Cory Decarbonisation Project

Thames water Utilities Limited

Deadline 6 Response

Figure 9 – Operational phase ProW diversions and ProW creations (repeat)

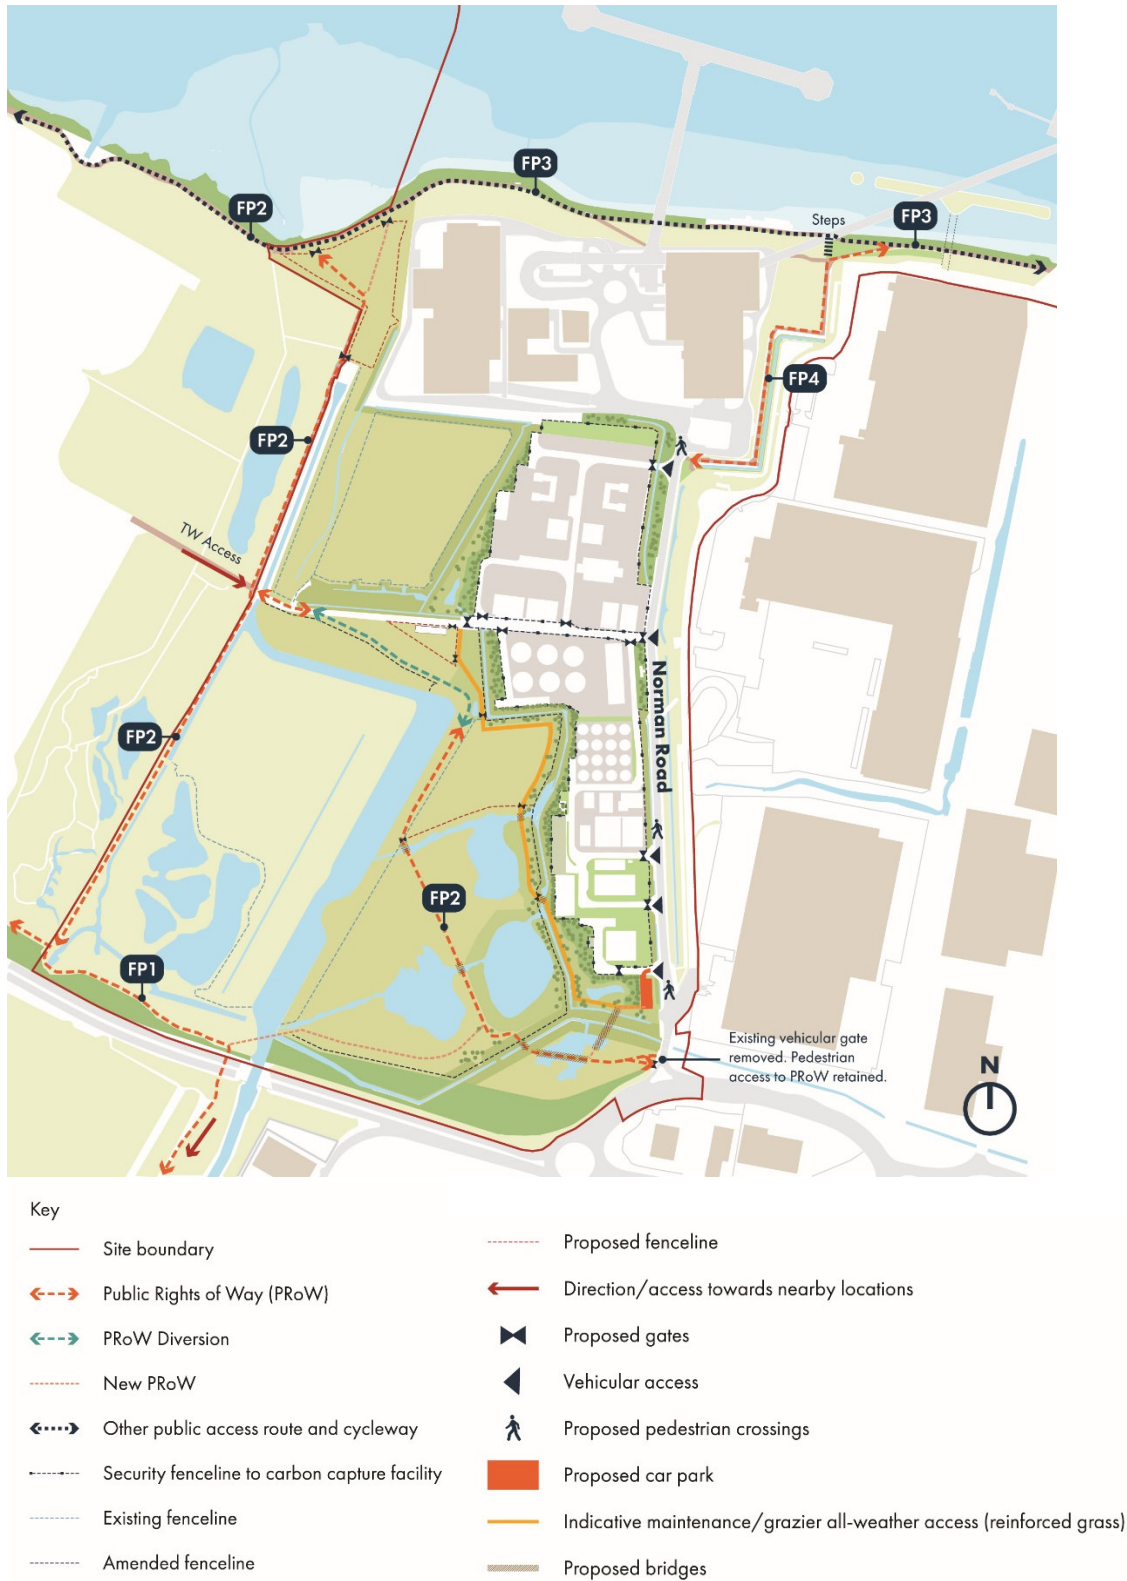
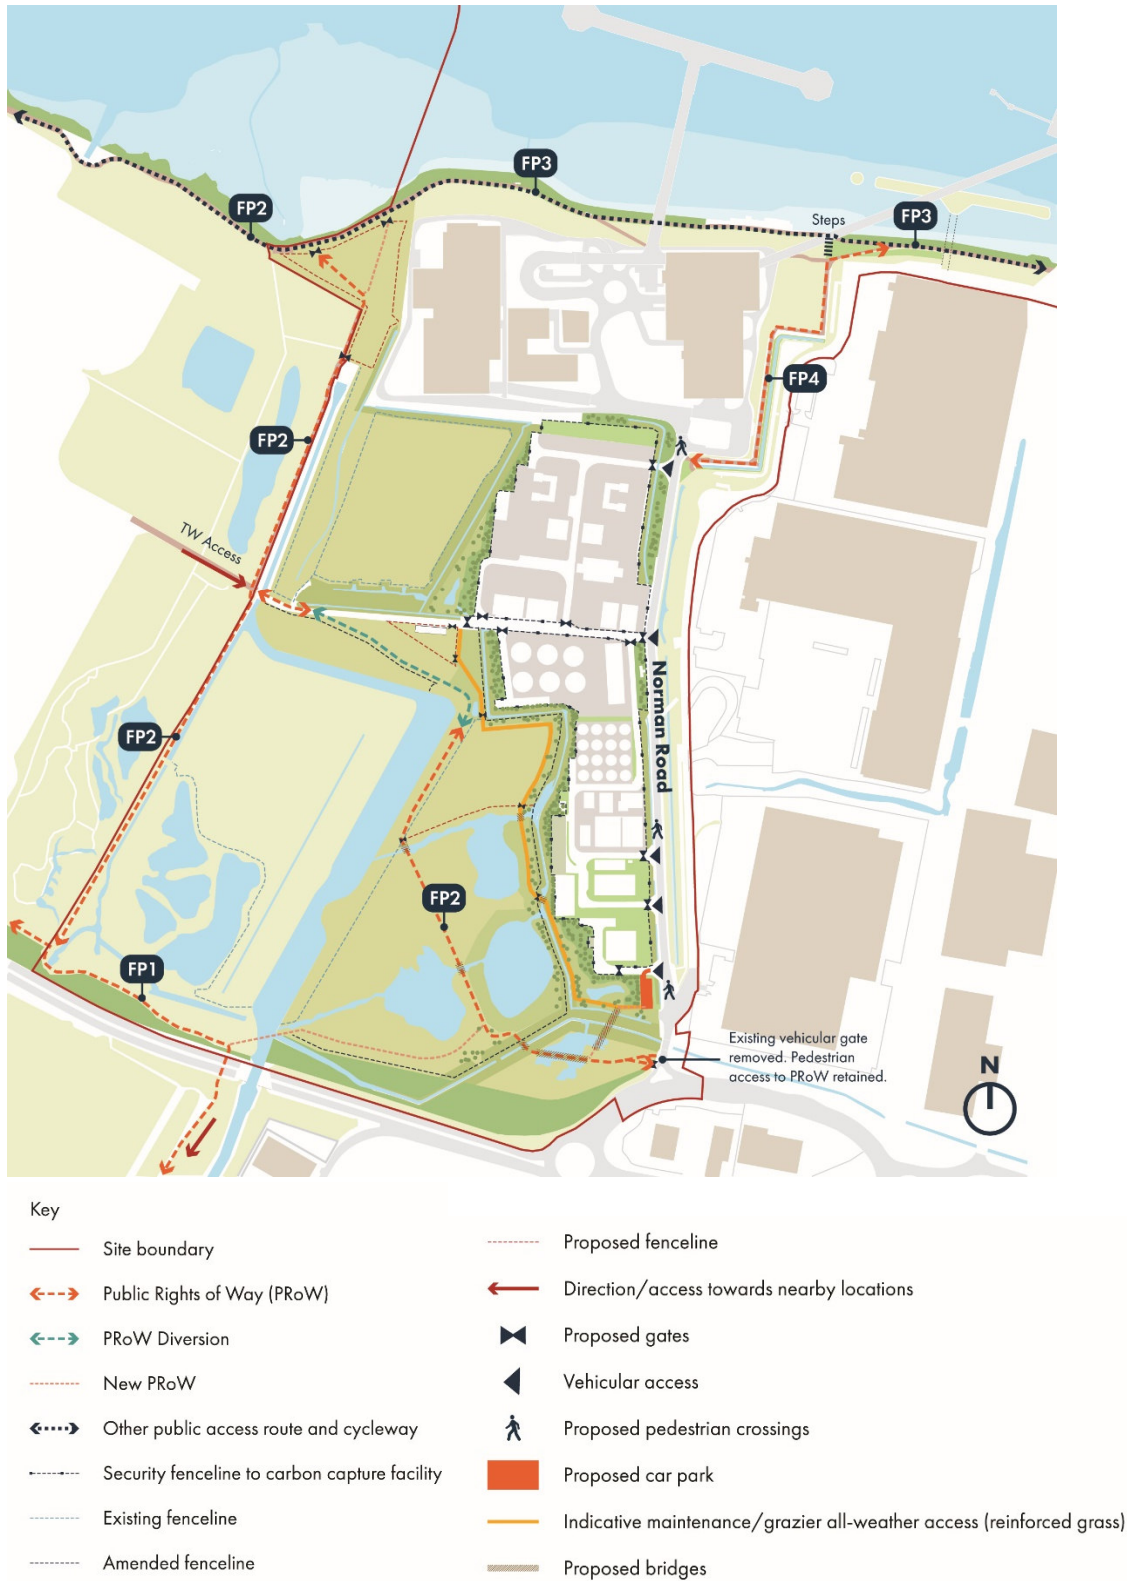
6.2 Paragraphs 10.2.8 to 10.2.11 set out some additional proposals for the CLNR, in particular that Cory will provide a new route for "maintenance and grazier access" to replace the TWUL emergency access, which is shown on the amended Figure 9. Clarity is required from Cory as to whether this means access to TWUL along the existing access for the purposes of maintaining the CLNR at present is to be revoked (and when) and, if so, whether the new route provides for vehicular access. Clarification is also required that the proposal does not affect TWUL's access to/egress from the Crossness STW, with or without vehicles.

- 6.4 From TWUL's perspective, the proposed changes to the route do not address any of the concerns already raised by TWUL and the CLNR groups to date, particularly with regards to:

- 6.4.1 the inappropriate location of proposed relocated stables;
 - 6.4.2 the further loss of habitat on TWUL land (including grazing land) with the Triangle and Lagoon Field lost/impacted, leaving only Island Field not directly impacted by this development;

- 6.4.3 further loss of existing habitat on Norman Road Field and in fact, including that which has significant ecological value (Frog Rush, Borrer's Saltmarsh Grass and other important plant species along the eastern boundary, as identified by Dr. Mark Spencer on behalf of the Save Crossness Nature Reserve campaign group in its written submissions, and those made during February's site visit);

- 6.4.4 TWUL's need for a road sufficient to accommodate maintenance vehicles (excavators, dump trucks etc associated with ditch management for example) and for the grazier's requirements: horse lorries or towing of horse-boxes, large vehicles bringing in winter hay etc.; and

- 6.4.5 the significant flooding potential of Norman Road Field, such that it is unusable in winter. This will only get worse when ground levels are raised and built structures placed in the vicinity as part of the CCF: a 'slightly-raised' path is considered will be unusable.

- 6.5 It is also considered that the management requirements of the proposed route will be significant due to: (a) its length; (b) being situated in a flood-risk wetland; and (c) being situated alongside the trees proposed for 'mitigation/screening'. This will result in considerable time requirements and expense which, although not a direct concern for TWUL (as TWUL will not agree to maintain the Norman Road Field), TWUL is concerned it will have an indirect impact on TWUL land.

- 6.6 Finally, the gateway proposed is also considered to be dangerous, as it is opposite the Asda distribution vehicle entrance and close to the dangerous corner of Norman Rd/Eastern Way. When TWUL has public events, cars are lined up along the Norman Rd for access. TWUL wishes to be clear that it will take no responsibility for the management of the proposed car park or any issues arising from it.
